Ref: 2024\ENQ\00082
Date: 14th May 2024
Enquiries Jess Duffield
Direct 01226 772589
E-Mail: jessicaduffield@barnsley.gov.uk

RE: Pre-application enquiry at the Land to the south of Doncaster Road, Darfield

Introduction

This pre-application enquiry seeks advice regarding a hybrid proposal for residential development. The site is allocated as housing allocation reference HS78 as defined in the adopted Local Plan.

**Doncaster Road Junction:**

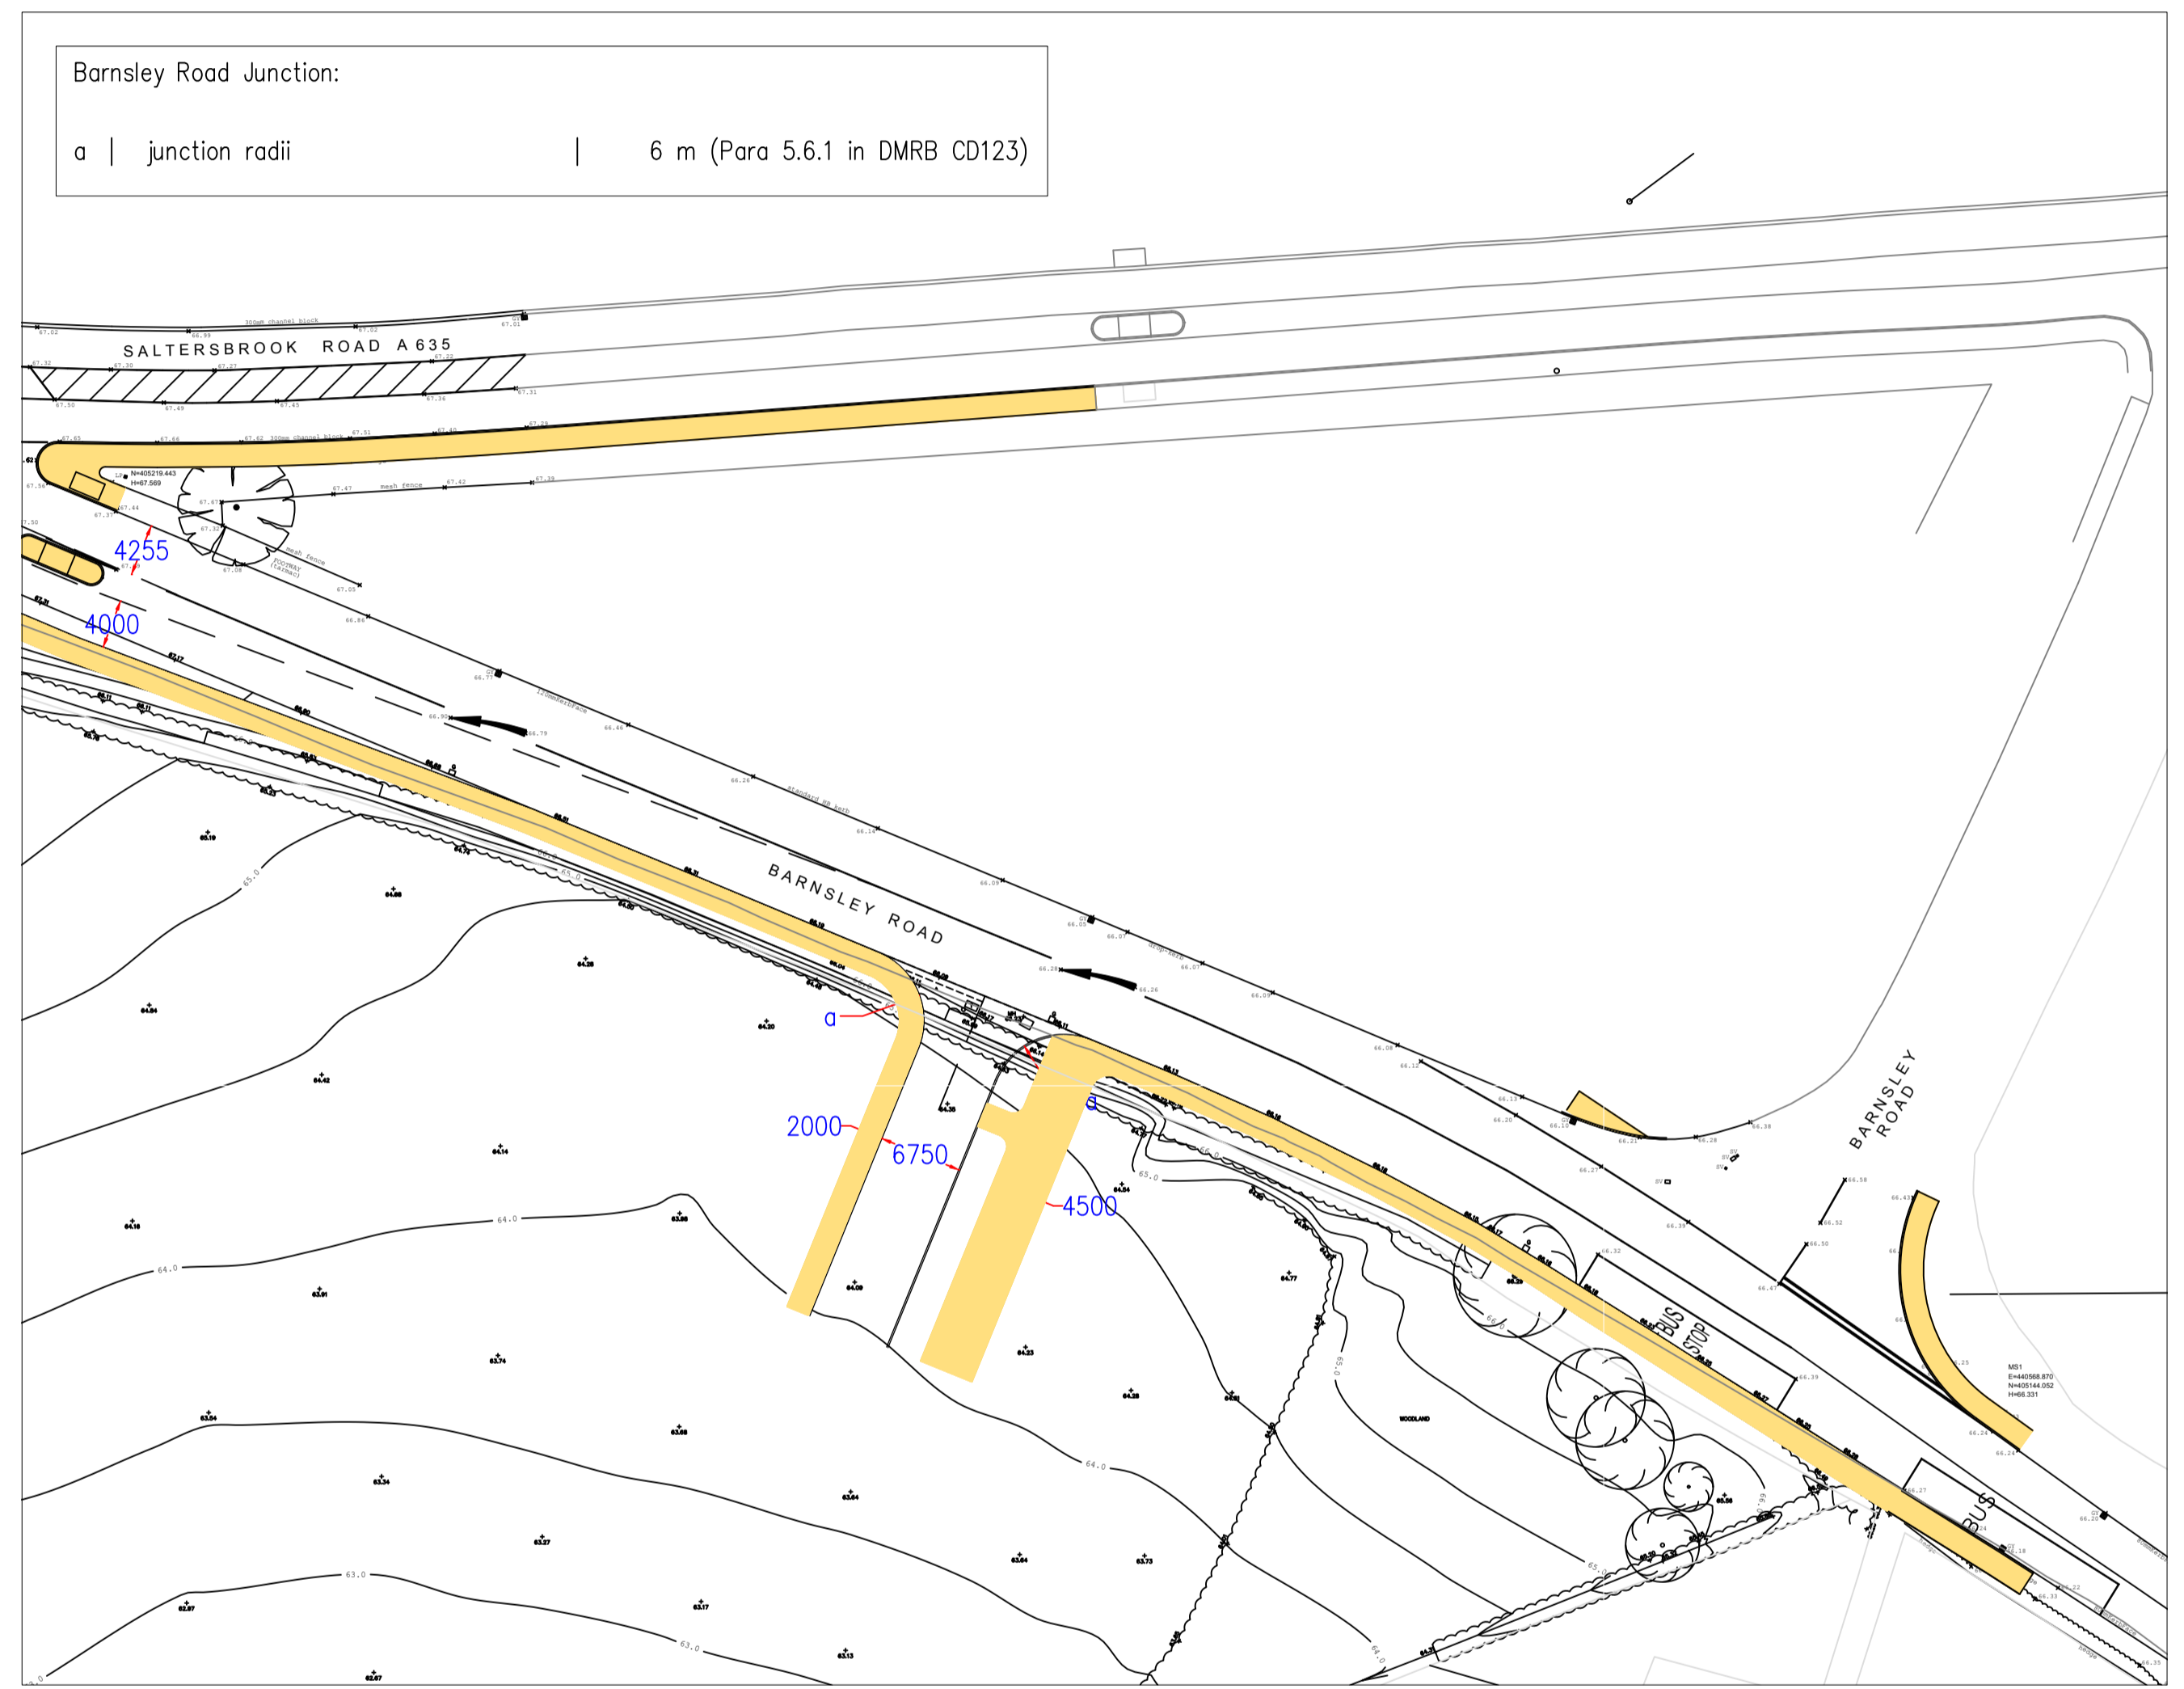
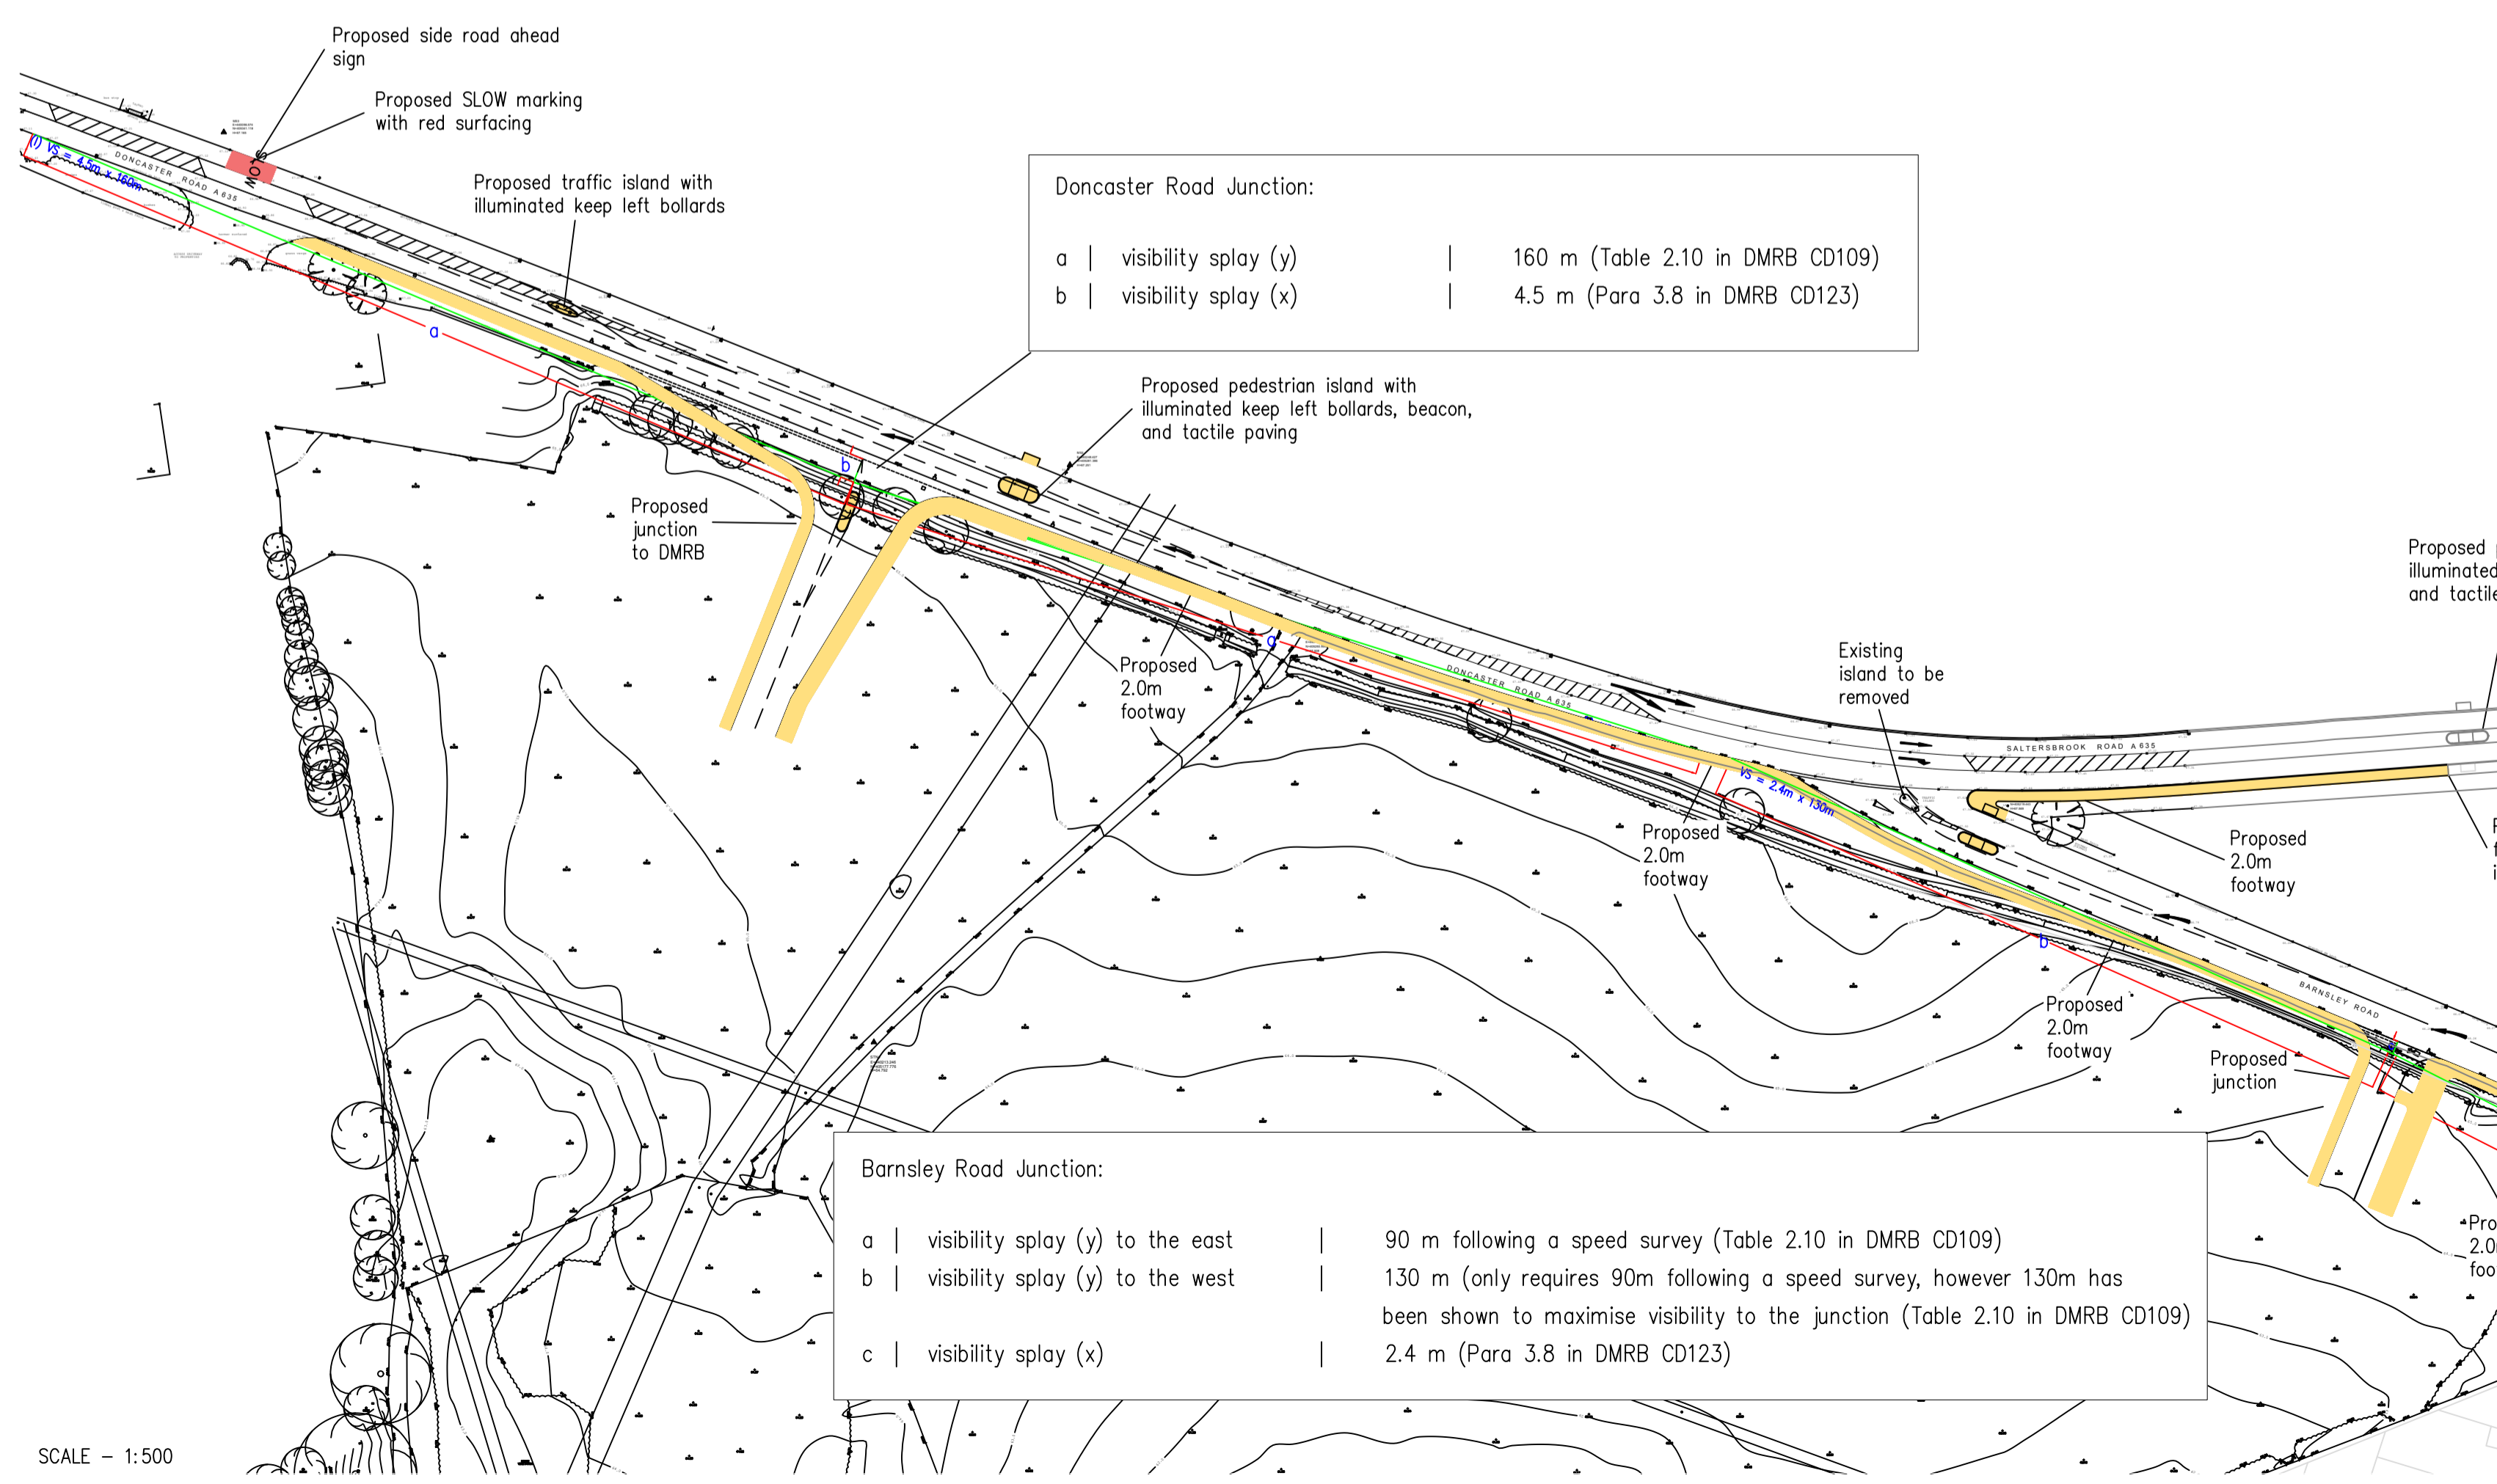
The pre-application submission provides a layout plan which includes the proposed new access. It is advised that a design checklist be provided to ensure that all aspects of the design are in accordance with the requirements as set out within CD123 of DMRB. The current layout proposes a priority junction with a ghost right turn pocket and pedestrian refuge islands. It should be noted in the first instance, that it will be necessary to provide crossing points that can accommodate cyclists given that there is both a 3m shared footway cycleway proposed within the development, and a shared footway/cycleway on the opposite side of the carriageway along Doncaster Road. As such, pedestrian refuge islands should be a minimum width of 3m with the appropriate lining offset thereafter. This will undoubtedly have an impact on the proposal and will result in the ghost right turn pocket requiring some widening.
